**Subject:** Upper South Creek Advanced Water Recycling Centre (SSI-8609189) Amendment Report

### Attachment 1 – EES biodiversity comments on the Upper South Creek Advanced Water Recycling Centre (SSI 8609189) Amendment Report.

#### *Sydney Region Growth Centres Biodiversity Certification - Kemps Creek re-alignment*

Matter: 31617,
Date: 30 June 2022,
Prepared for: CW, Prepared by: AM, Last edited by: lharley
Layout: 31617_ImpactsToENV
Project: P:\31600s\31617\Mapping\31617_WaterFactory.aprx

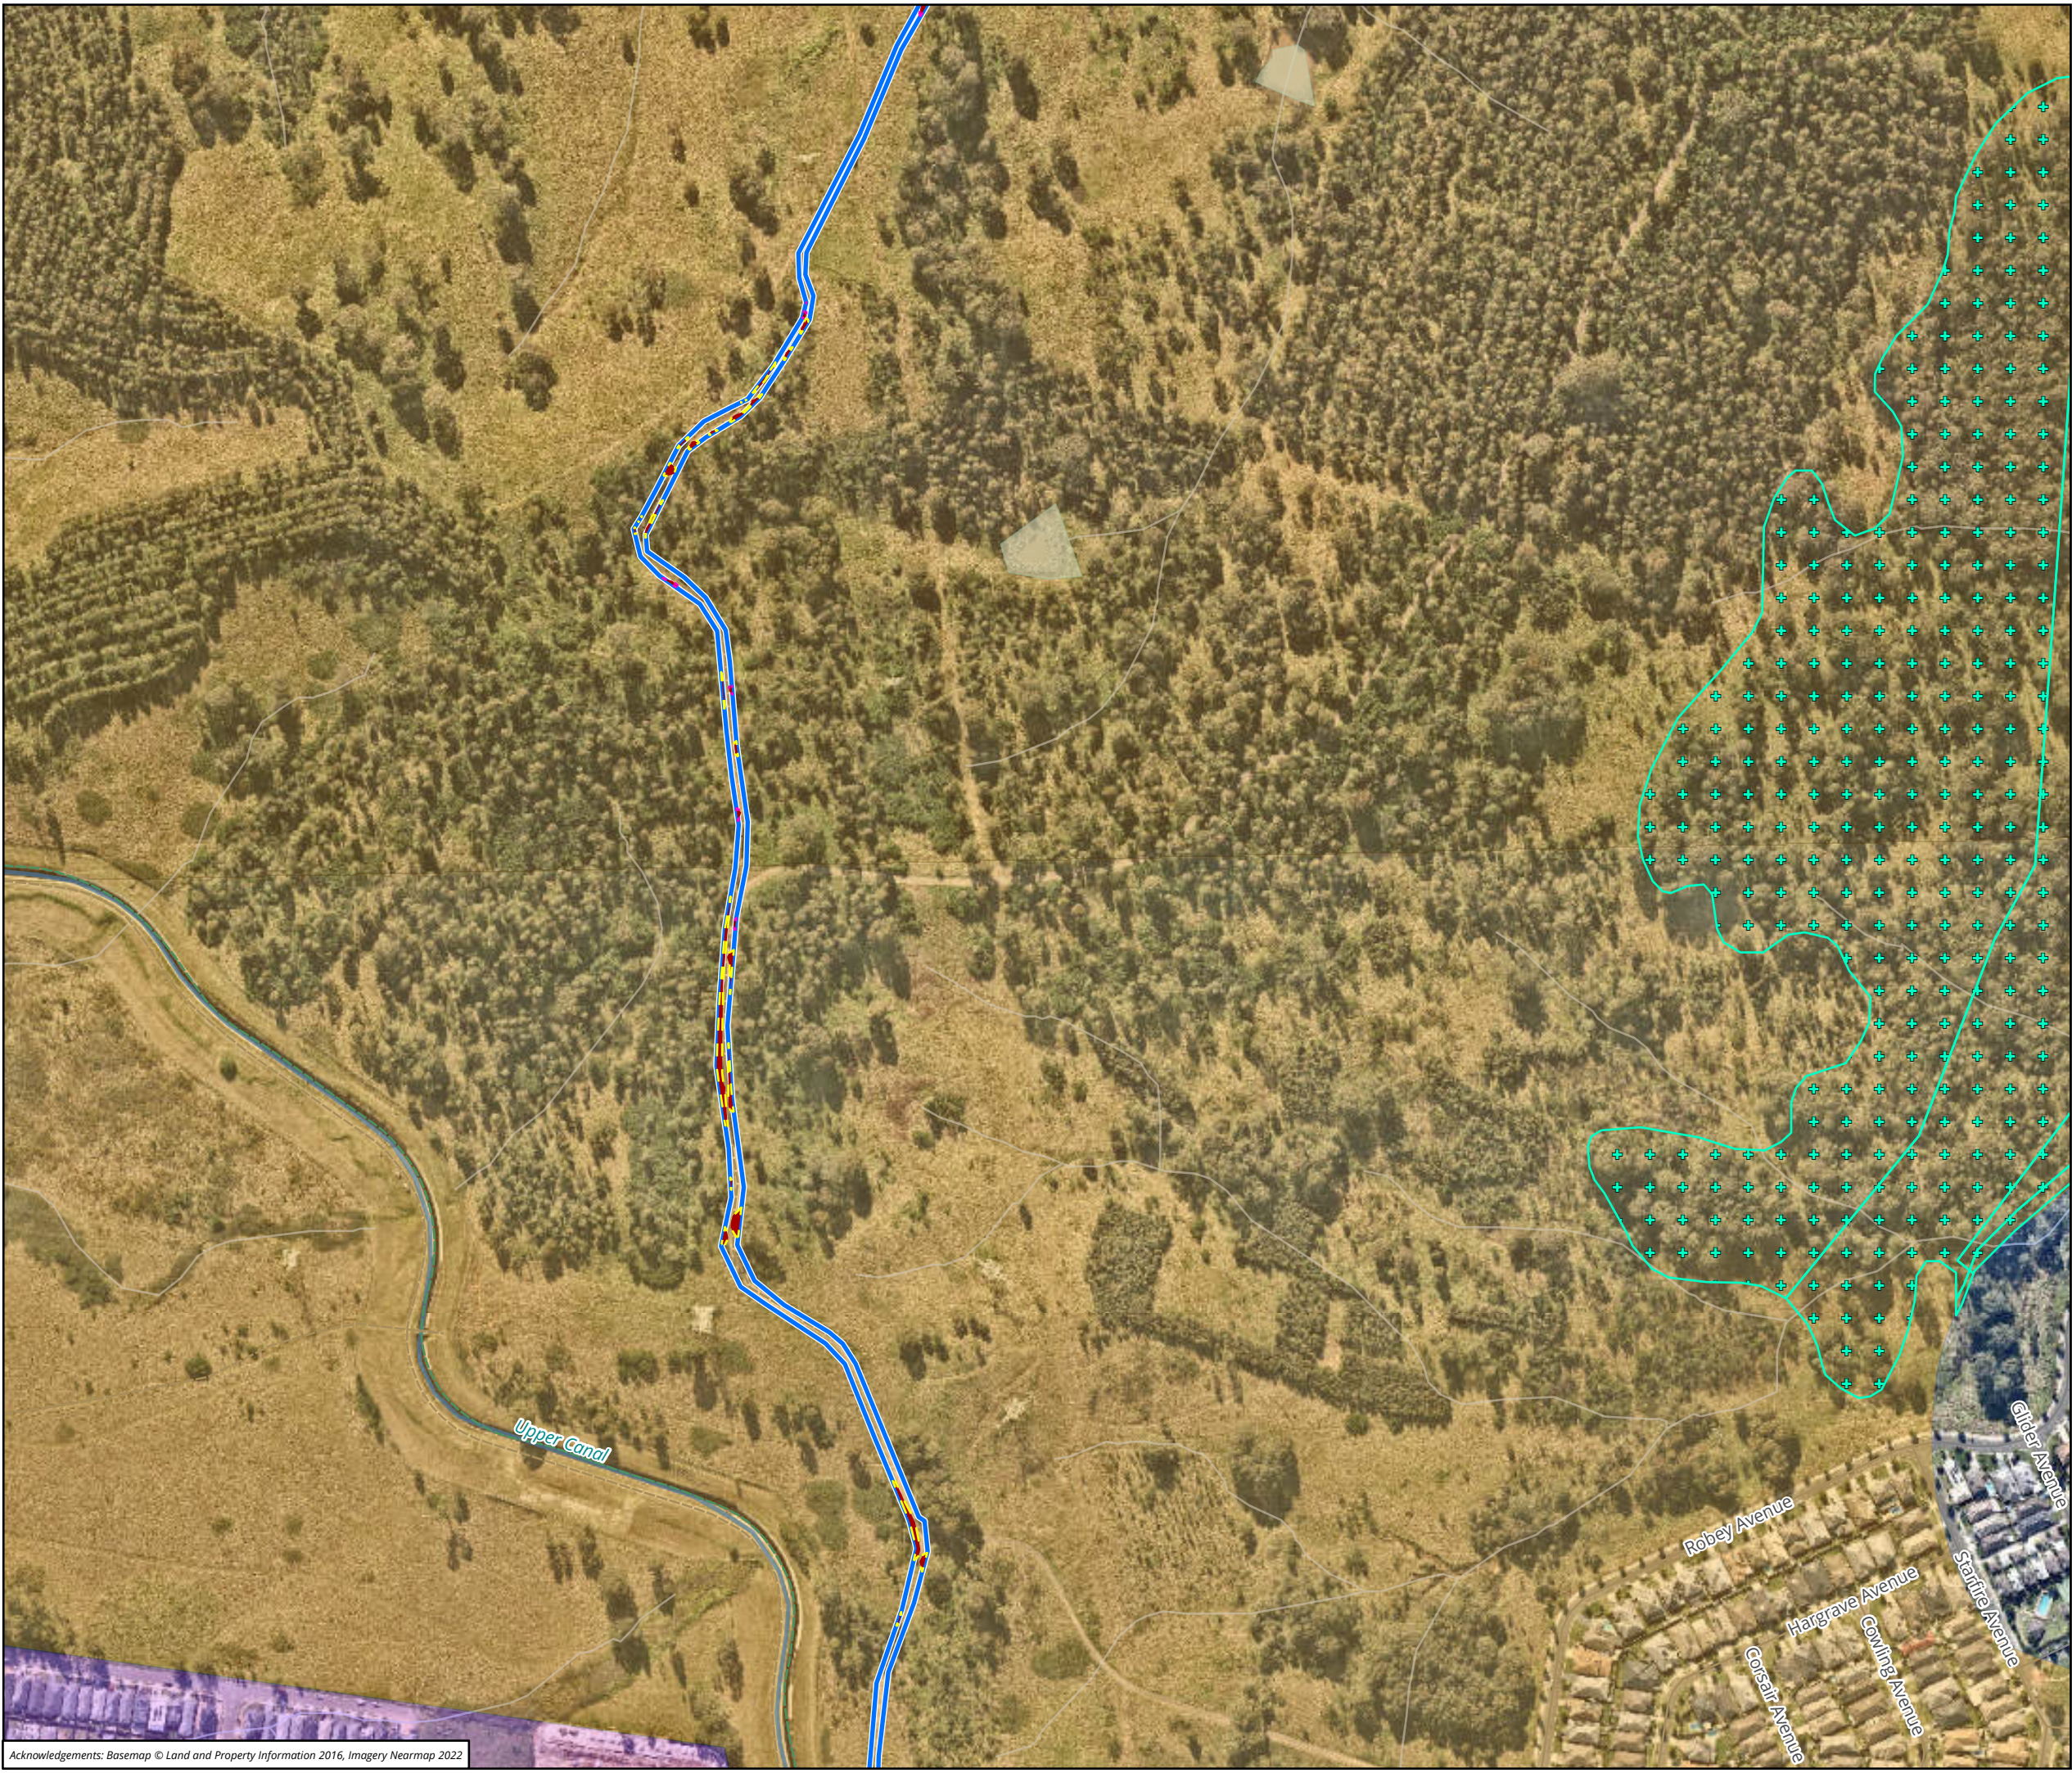
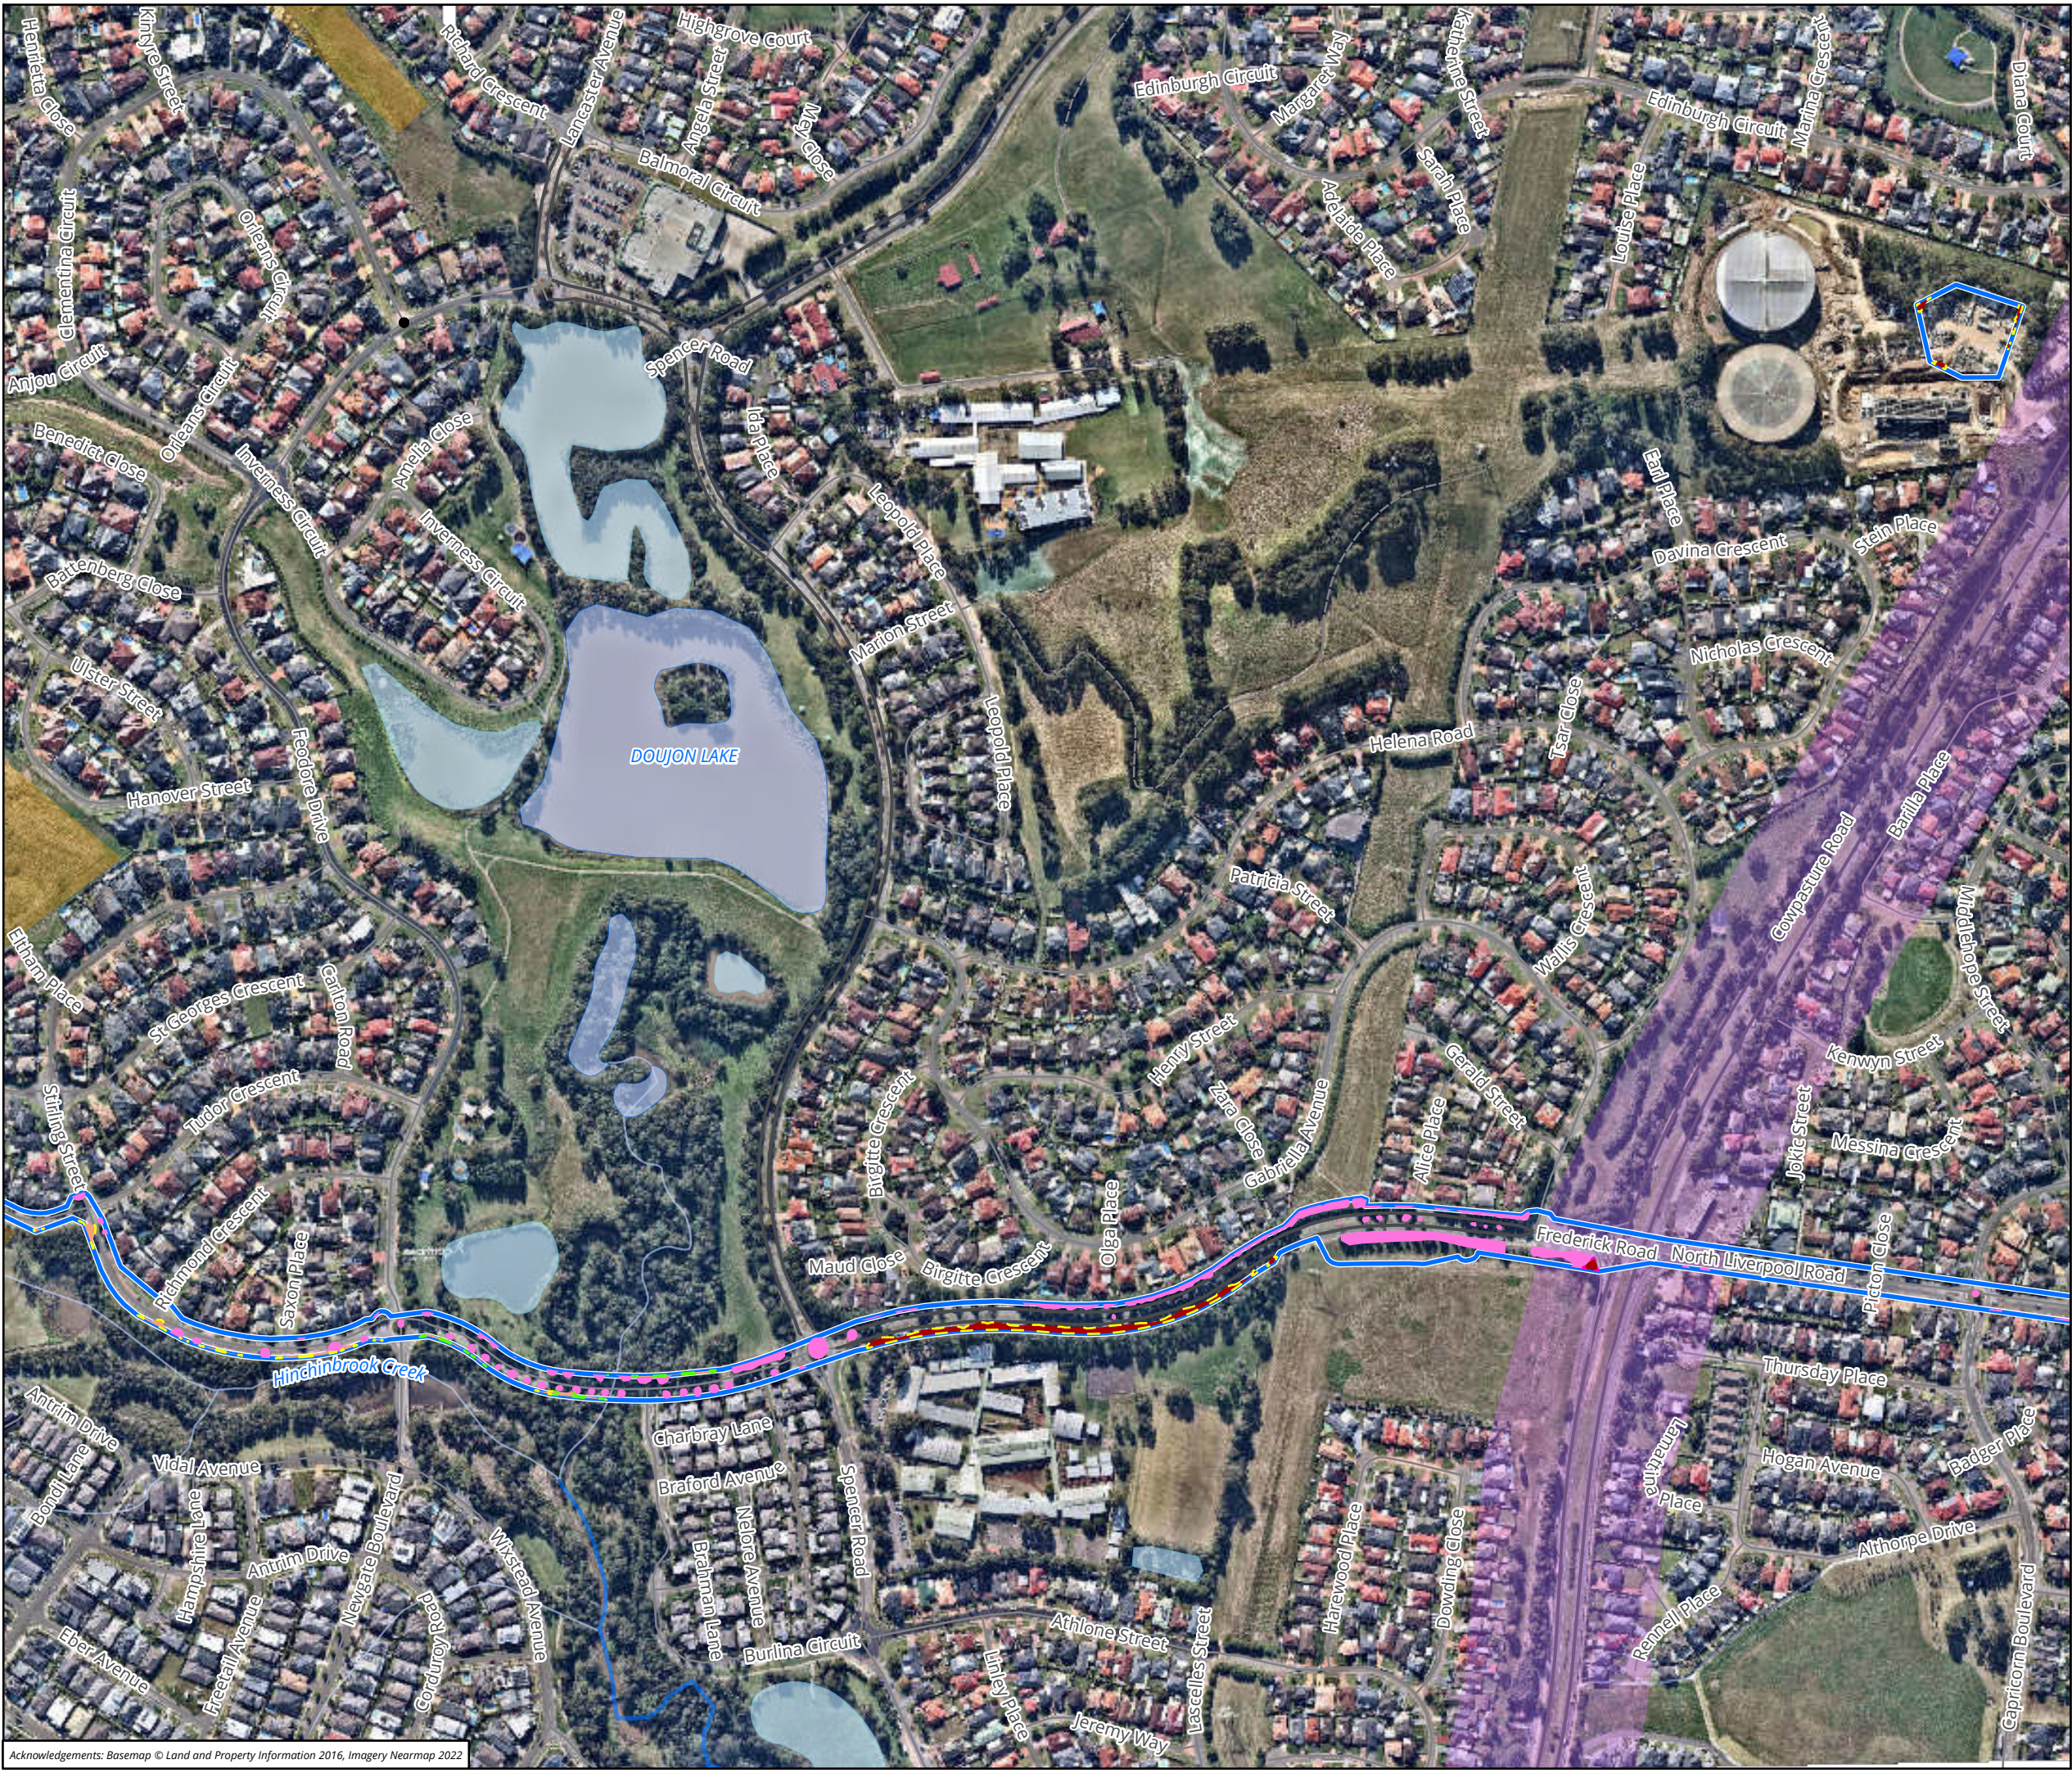
The Amendment Report proposes to realign and construct the AWRC pipeline to within this currently cleared corridor. EH seeks confirmation that no further impacts to ENV will occur from the proposed amended realignment and the pipeline construction and operation. The RtS report should include ENV on the maps in addition to the RMB 12 red hatched area.
